**Nationally Significant Infrastructure Project: EN070008  
Viking CCS Pipeline**

**Response to The Examining Authority's written questions and requests for  
information (ExQ1) issued on 3 April 2024**

**Prepared by Lincolnshire County Council (LCC)**

**April 2024**

FIGURE TITLE
 Figure 7-5
 Zone of Theoretical Visibility
 Immingham Facility at 25m Height

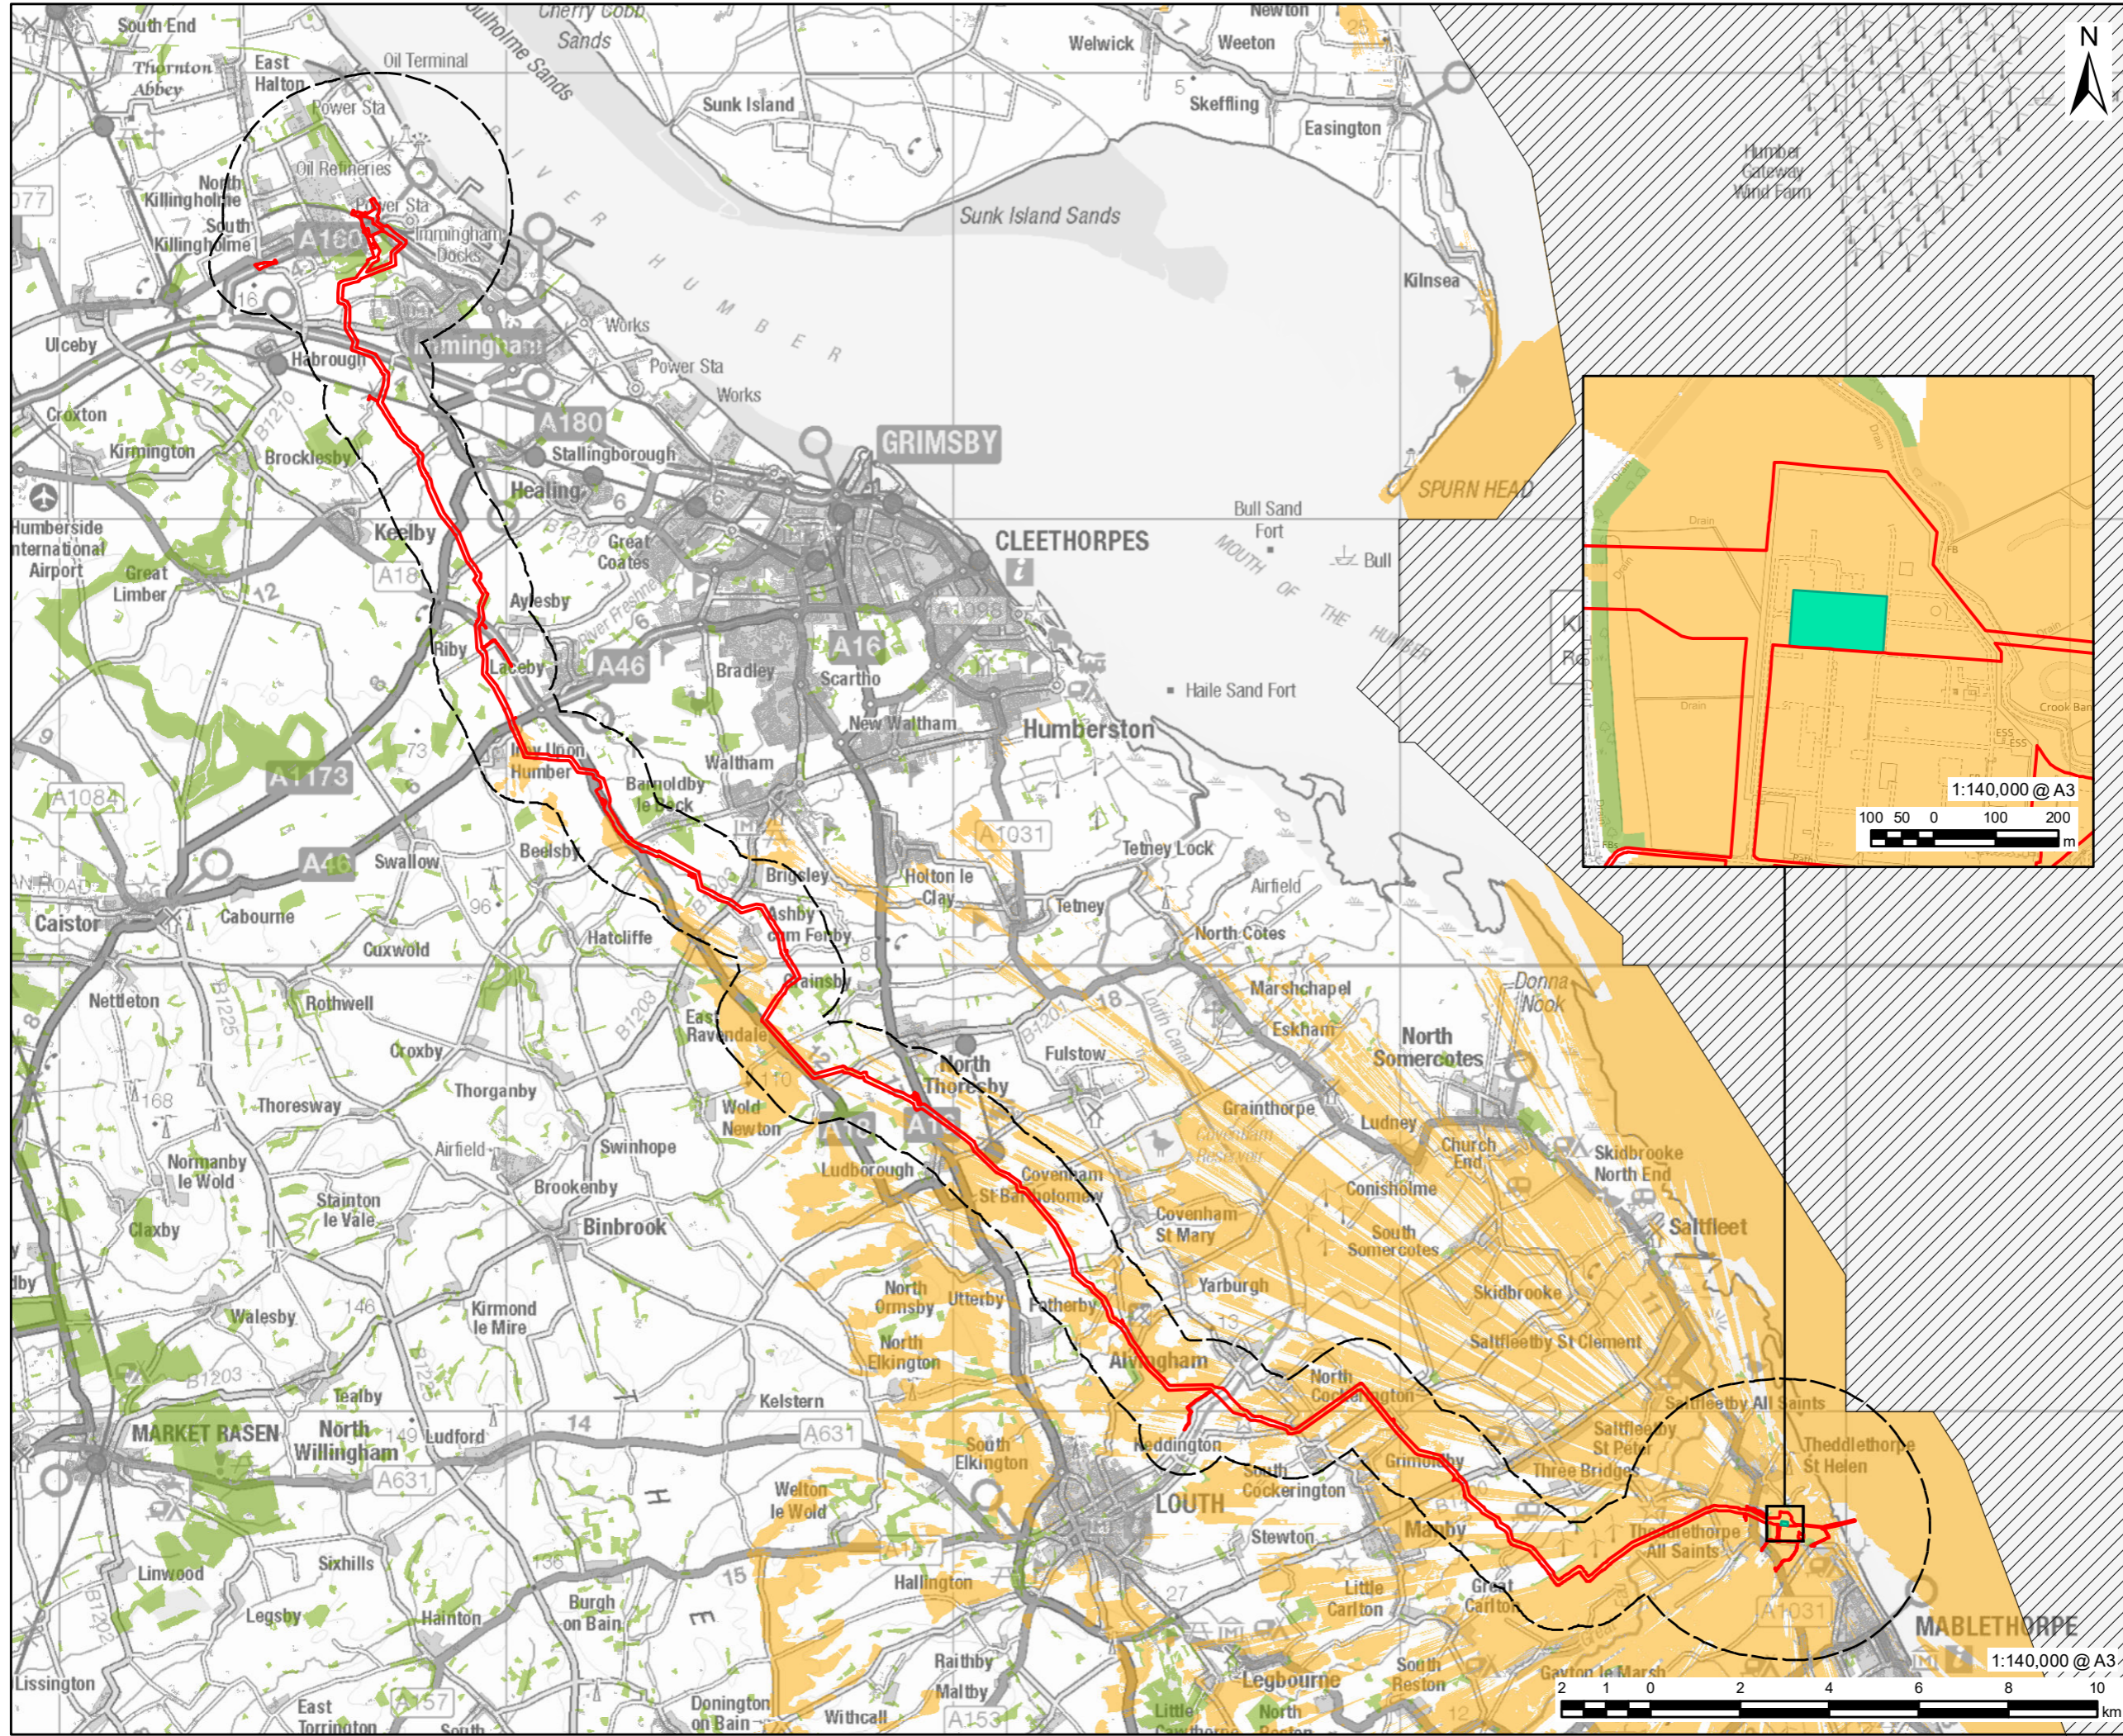
1.13.3	<p><b>Zone of Theoretical Visibility (ZTV)</b>            Figure 7-5 [APP-049] sets out the ZTV for Immingham. It is noted that from this, there are no viewpoints provided to the Examination of the IAGI from the northern side of the Humber (such as Spurn Head). Could it be explained why this is the case?</p>	<p>This area falls outside of LCC administrative boundary and as such we have not had any previous discussion with the applicant on viewpoints for the Humber area. We therefore have no comments to make and would defer this to North Lincolnshire and North East Lincolnshire Council's.</p>
